Revised calculations and drawings as requested to remove the discharge conditions for the Pound Place development.

I have the following comments regarding condition 3- surface water drainage:

DRAWING TITLE:
PROPOSED
IMPERMEABLE AREAS
SHEET 2

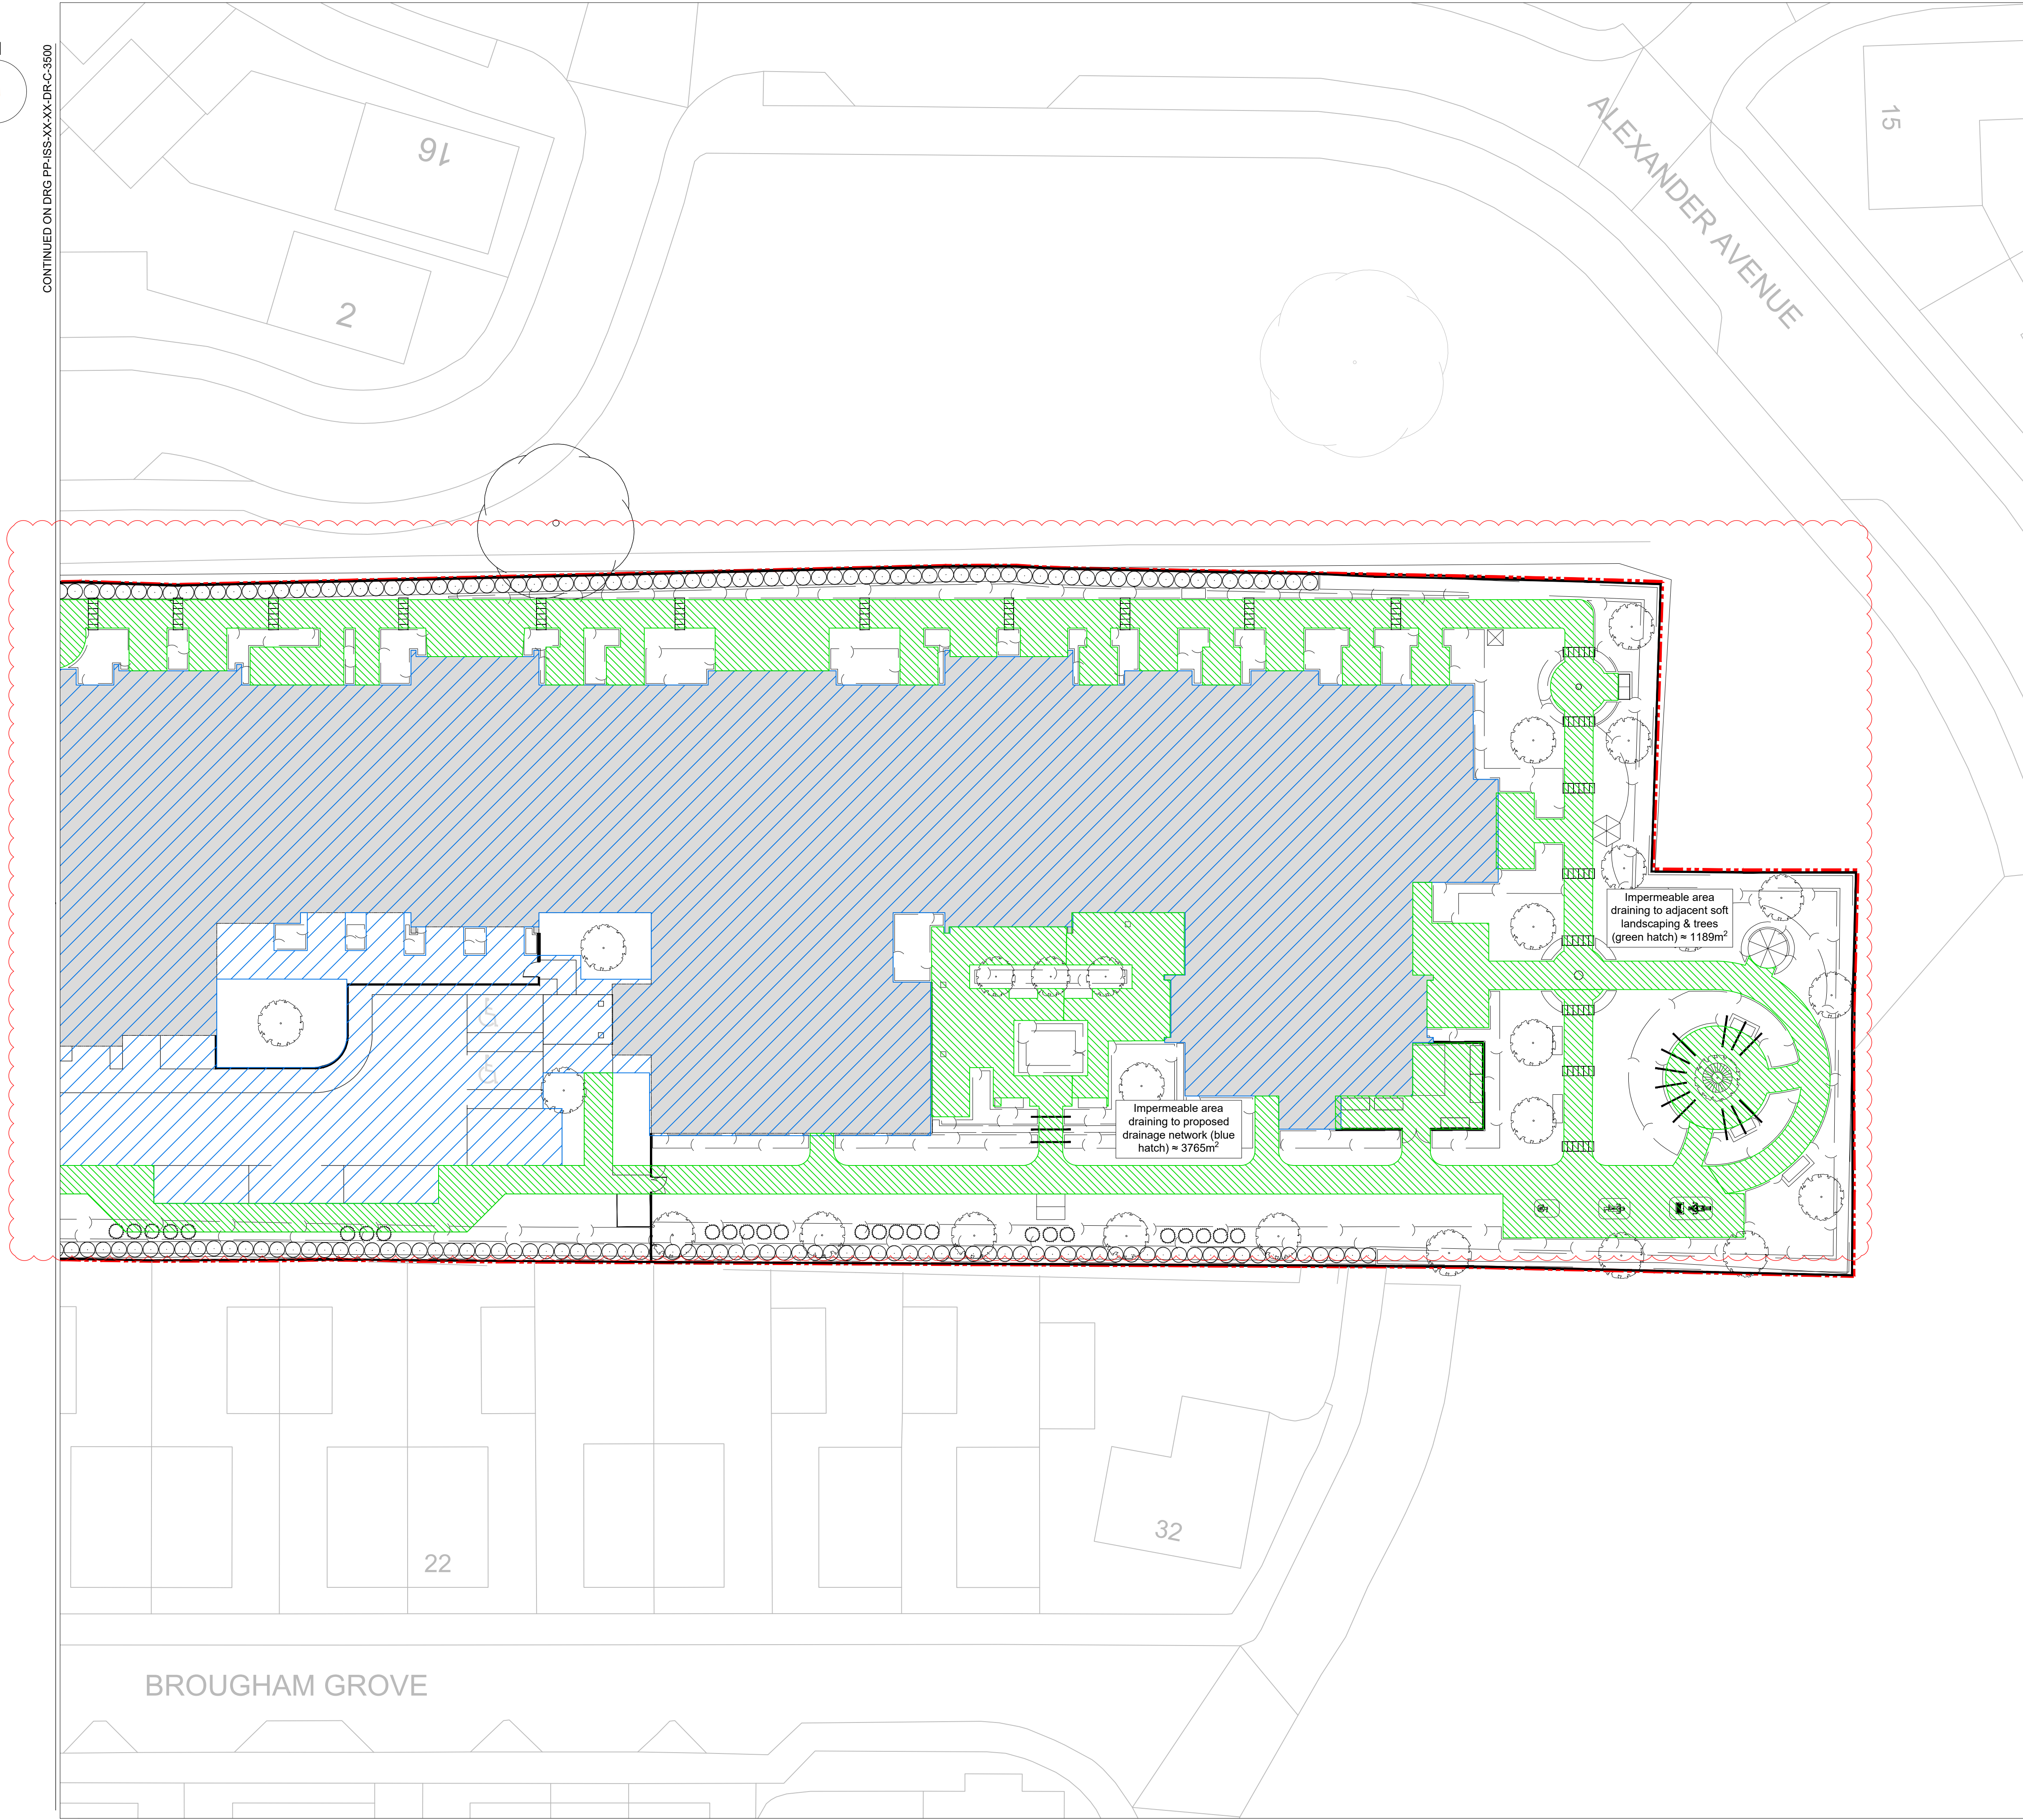
2. Please provide a revised catchment area plan. *Revised catchment plan provided (dwg PP-ISS-XX-XX-DR-C-3500 to PP-ISS-XX-XX-DR-C-3501) Please break this down to areas going to each soakaway, rather than just providing total impermeable area for the site.*

Dwg 3501 has a typo in the dwg but the areas are correct. Please disregard the dwg from the above email and use this PDF copy. My apologies.
